Rosefield Solar Farm

Applicant's Response to Deadline 4 Submissions

EN010158/APP/8.32
Revision 01
Deadline 5
July 2026
Rosefield Energyfarm Limited

Date: 10/02/2023

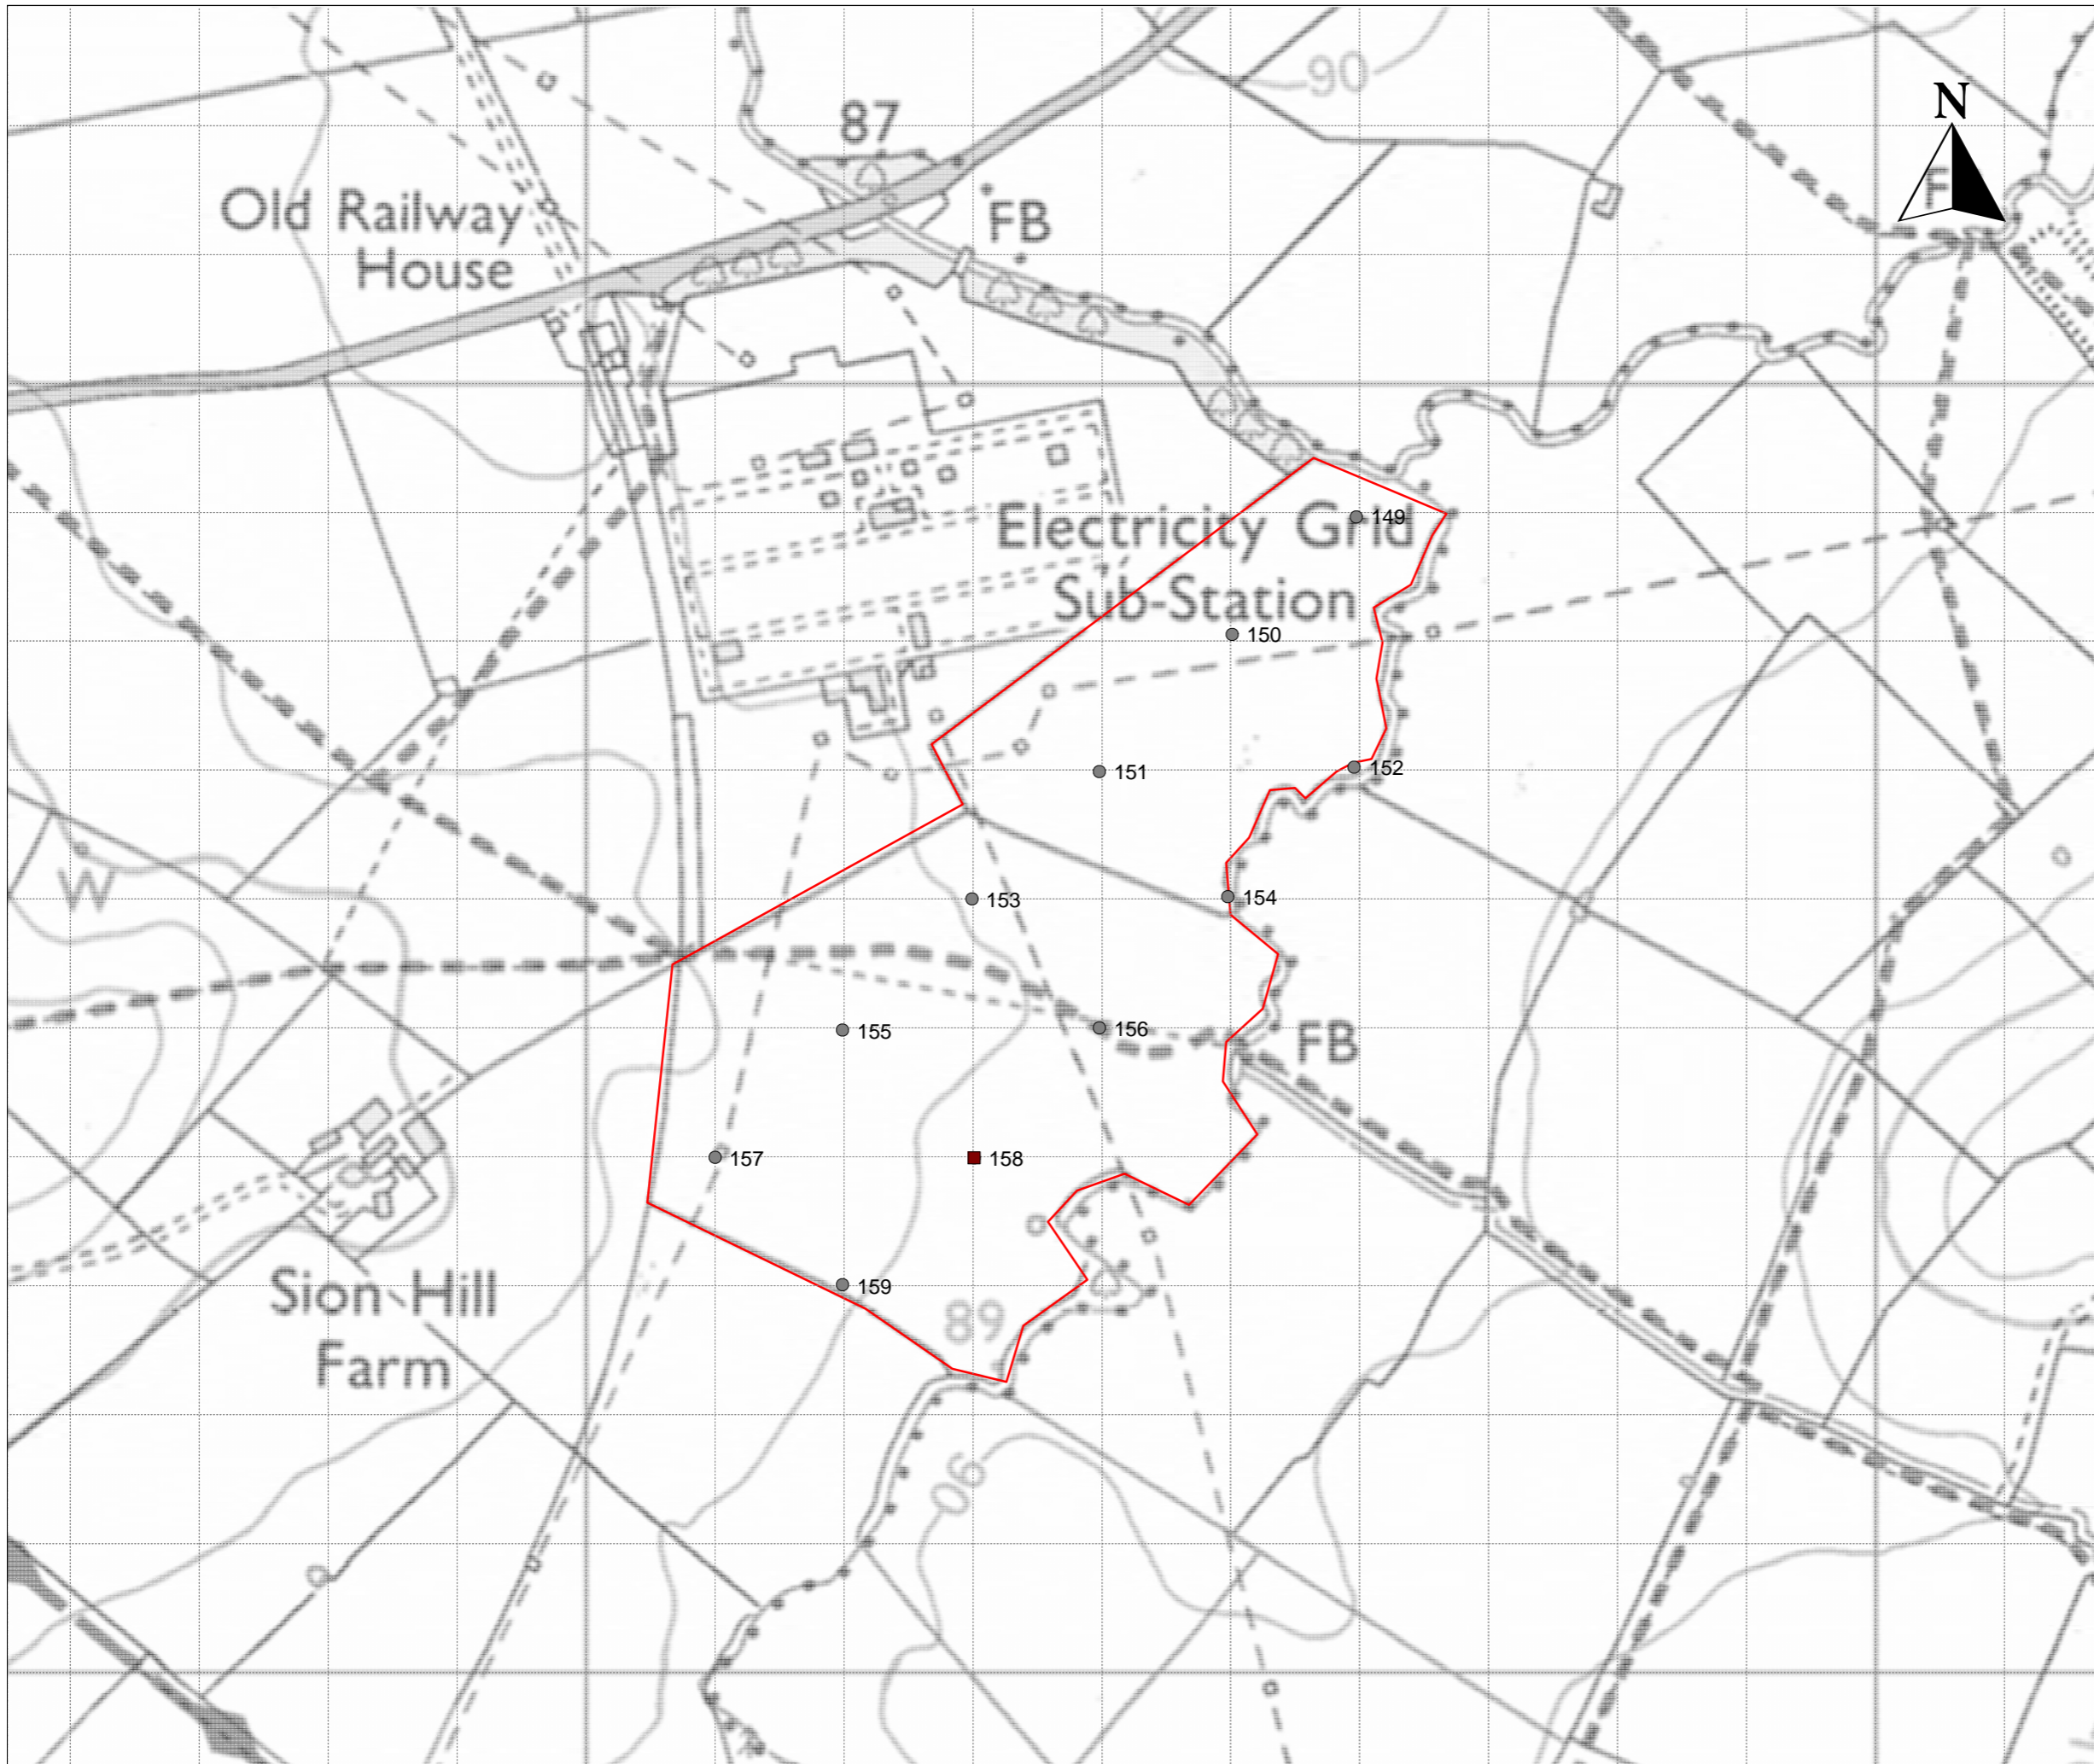
3.39	John Philip Claridge [REP4-105], Page 2	Comment noting that point 45 within the Agricultural Land Classification Report is marked as being surveyed, though the party considers this to be untrue and misleading. Comment noting that the Report does not accurately reflect the party's understanding of the land within their holding. Further comment that the soil type of the party's land to be Grade 3a, not Grade 3b.	Point 45 is a pit that was dug as part of the ALC survey conducted by LRA in January 2023, the results of which are presented in ES Volume 4, Appendix 12.1: Agricultural Land Classification Report [EN010158/APP/6.4.3] to assign the land an ALC Grading. Surveyors began discussions with the Claydon Estate regarding the ALC surveys in September 2022, and met Mr Claridge on-site in person on 23 January 2023. Access was granted for the land east of Knowl Hill, including pit 45 and auger points 47,52,46, 51 & 64 (those contested by Mr Claridge) on 24 and 25 of January 2023. Annex 3a in ES Volume 4, Appendix 12.1: Agricultural Land Classification Report [EN010158/APP/6.4.3] mistakenly shows four soil pits, including pit 45 mentioned by Mr

Ref.	Submission Reference and Identifier	Summary Position	Applicant's Response
			Claridge, as having been dug by RSK ADAS. These pits were actually dug by LRA, as is correctly shown in Annex 3b. Annex 3a, showing the RSK ADAS auger and pit locations, has been updated at Deadline 5 to remove reference to pits dug by LRA. The ALC Grade 3b was assigned in accordance with the 1988 MAFF guidance 'Agricultural Land Classification for England and Wales: Revised Guidelines and Criteria for Grading the Quality of Agricultural Land'. Auger boring logs in Annex 4a of ES Volume 4, Appendix 12.1: Agricultural Land Classification Report [EN010158/APP/6.4.3] show land in this area to have a gleyed slowly permeable layer within 40cm. Combined with the Site field capacity days of 136-142, as specified in Table 4.1, this places the soils in Wetness Class IV. Clay and Clay loam soils in Wetness Class IV are assigned a Grade according to wetness of 3b, which in this instance is the overall ALC Grade for this area of land.
